COUNTY COUNCIL'S RESPONSE TO CONSULTATION ON THE FOLLOWING DEVELOPMENT PROPOSAL

Application No: 18/00904/F-3

Proposal: Formation of inland waterways marina with ancillary facilities building, car parking, access and associated landscaping including the construction of a new lake

Location: Glebe Farm Boddington Road Claydon Banbury OX17 1TD

Fig 7.12.

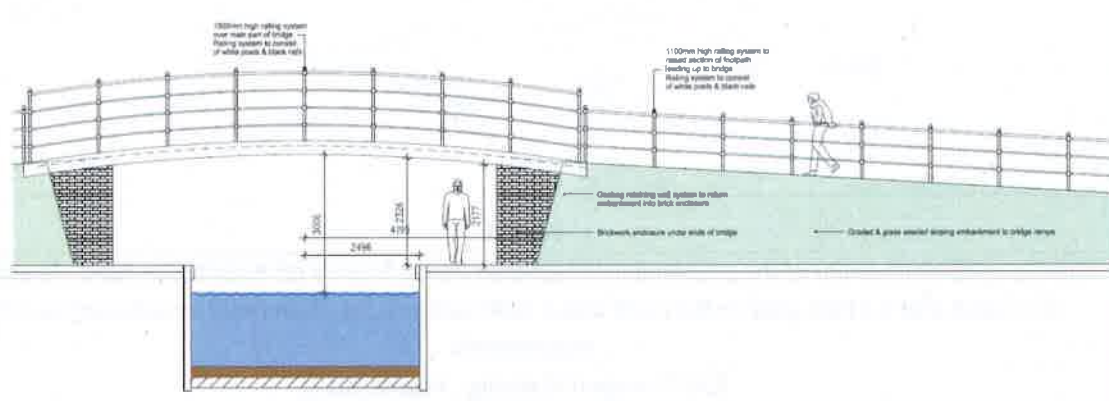
The proposed footbridge should be constructed to DMRB standards, or to Canal and River Trust (C&RT) public towpath standard. This structure must be maintainable by the applicant or C&RT and OCC accepts no liability for its construction, public liability or future maintenance. The footpath/towpath will need to be closed to enable construction and a temporary closure needs to be applied for from OCC. Note that there is normally a 12 week lead time for this. It is expected that the footpath/towpath will be protected from plant damage and repaired to same or higher standard after the works have been completed.

**Proposed Highways Access**  
Scale 1:200

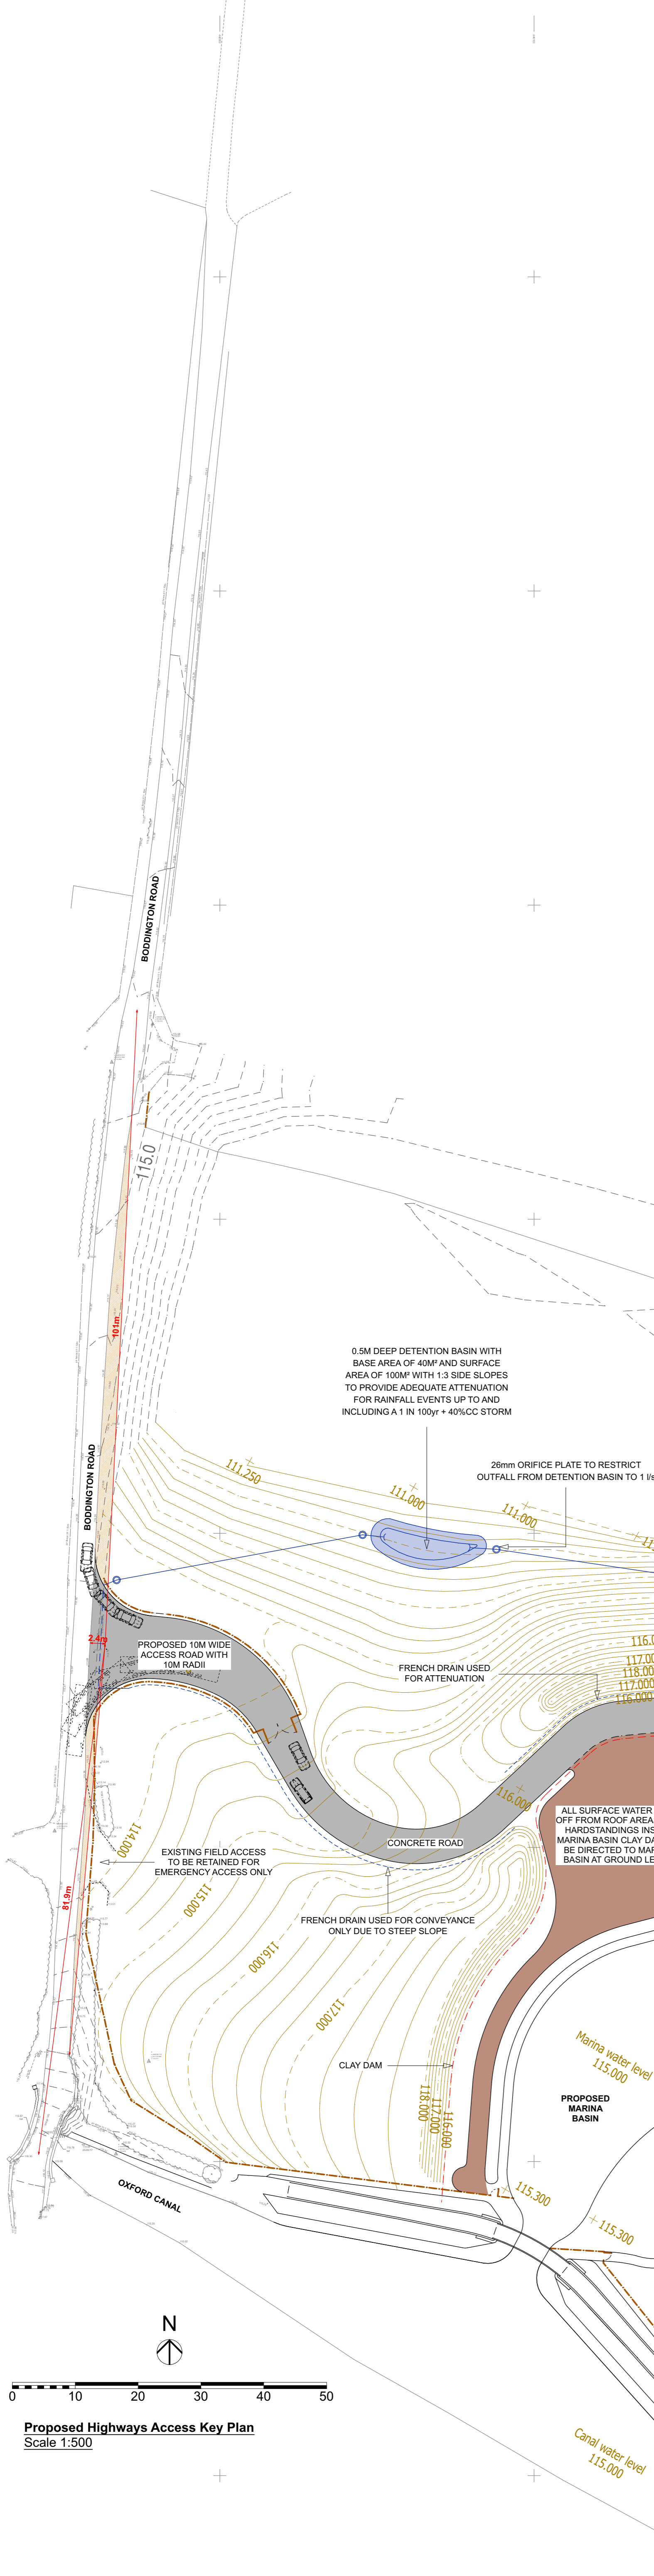
The position of the proposed site access has been amended (from its position proposed in the previous application) in order to avoid any encroachment into the floodplain slightly to the north of the site. This move has resultantly brought the access closer to the hump-back bridge along Boddington Road. Illustrations of the proposed access appended to the Transport Assessment (TA) shows that the new access position benefits from about 82m visibility splays from the crest of the hump-back bridge, which is considered to be the critical pinch point along this frontage.

Swept path analysis for an 11.2metre long refuse collection truck is shown to enter and also leave the site with left in/right out manoeuvres. No left out turn has been provided, which to my assumption is that large vehicles such as this one shall avoid accessing the site from the south (via the hump-back bridge).

Prior to the commencement of the development hereby approved, full details of the means of access between the land and the highway, including, position, layout, construction, drainage and vision splays shall be submitted to and approved in writing by the Local Planning Authority. Thereafter, the means of access shall be constructed and retained in accordance with the approved details.

Fig 7.5.

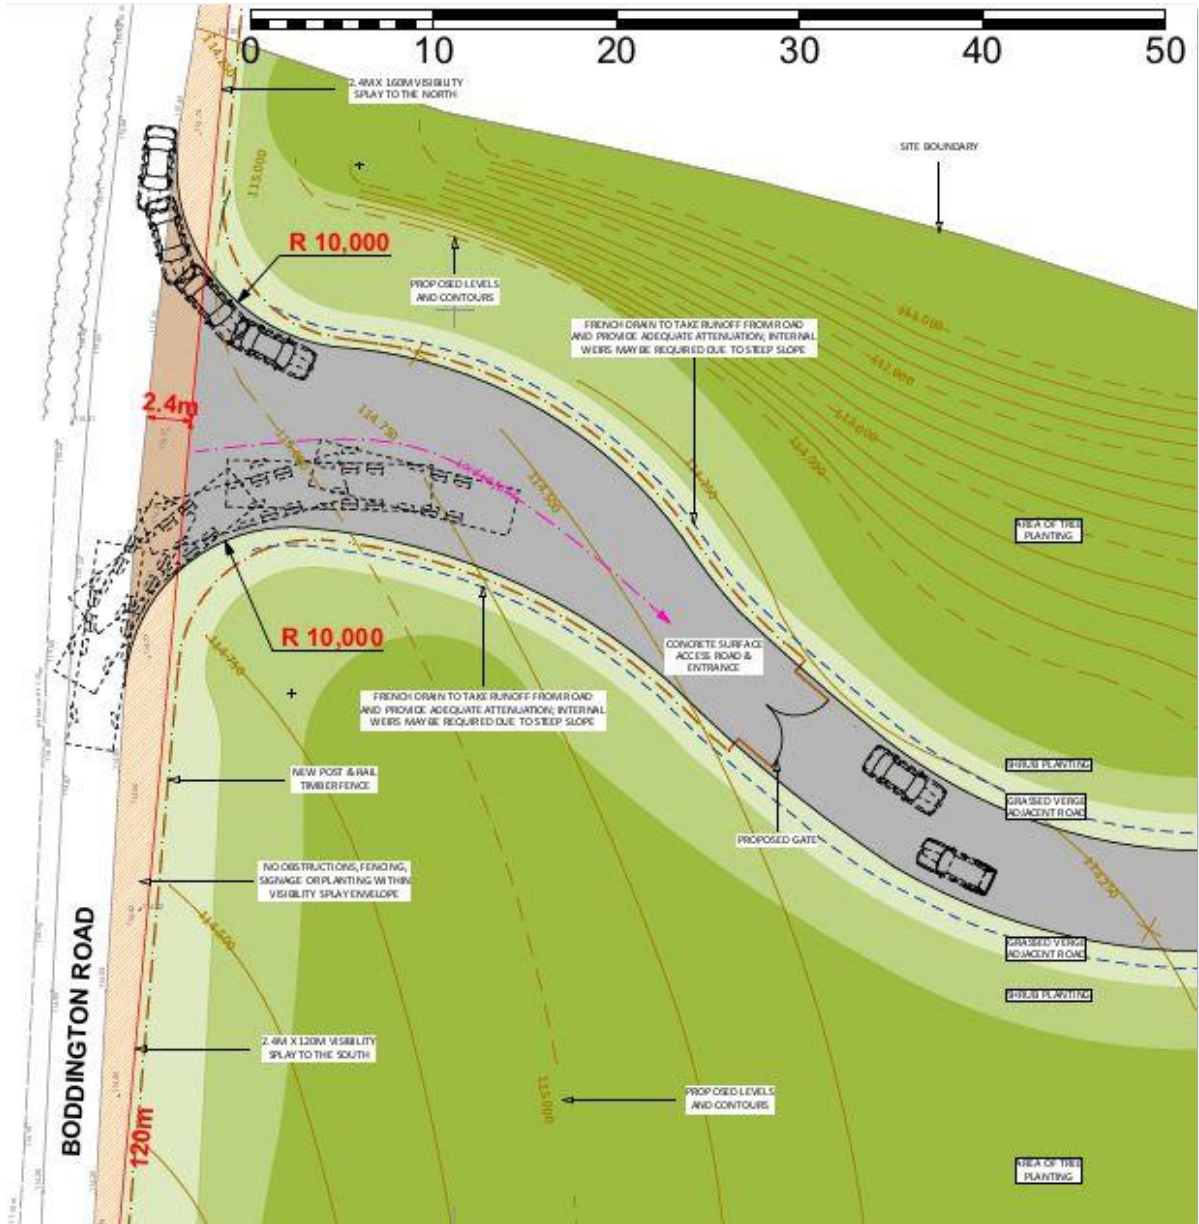
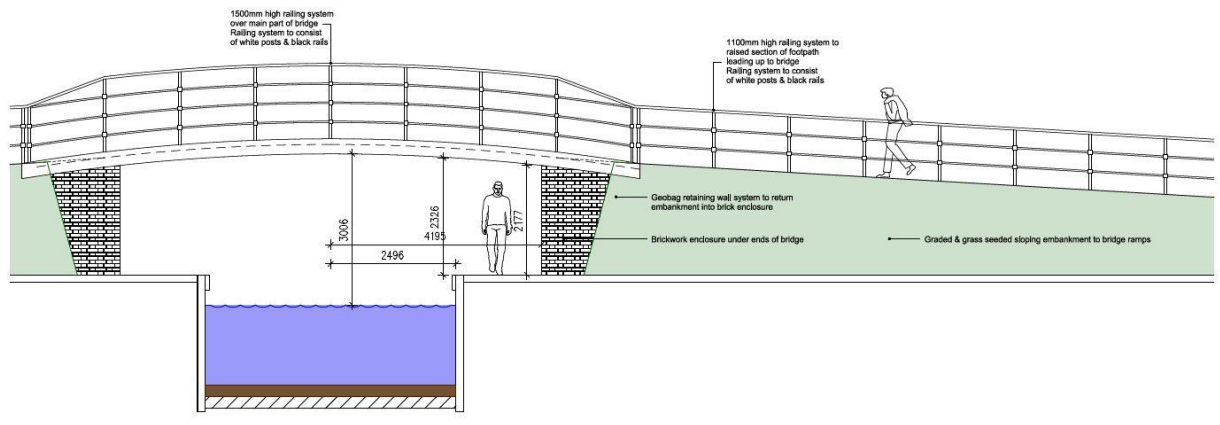
My initial opinion from a site visit undertaken in June 2018 was that the required visibility splays could not be achieved for a national speed limit road. Subsequent TA's have however included traffic surveys that have demonstrated that the average speeds of vehicles going past the site are significantly low. To this effect, and in consideration of the physical constraints of Boddington Road such as the hump-back bridge south of the site and the bendy and narrow characteristics of Boddington Road, I am now convinced that the adjacent highway would command relatively low speeds.
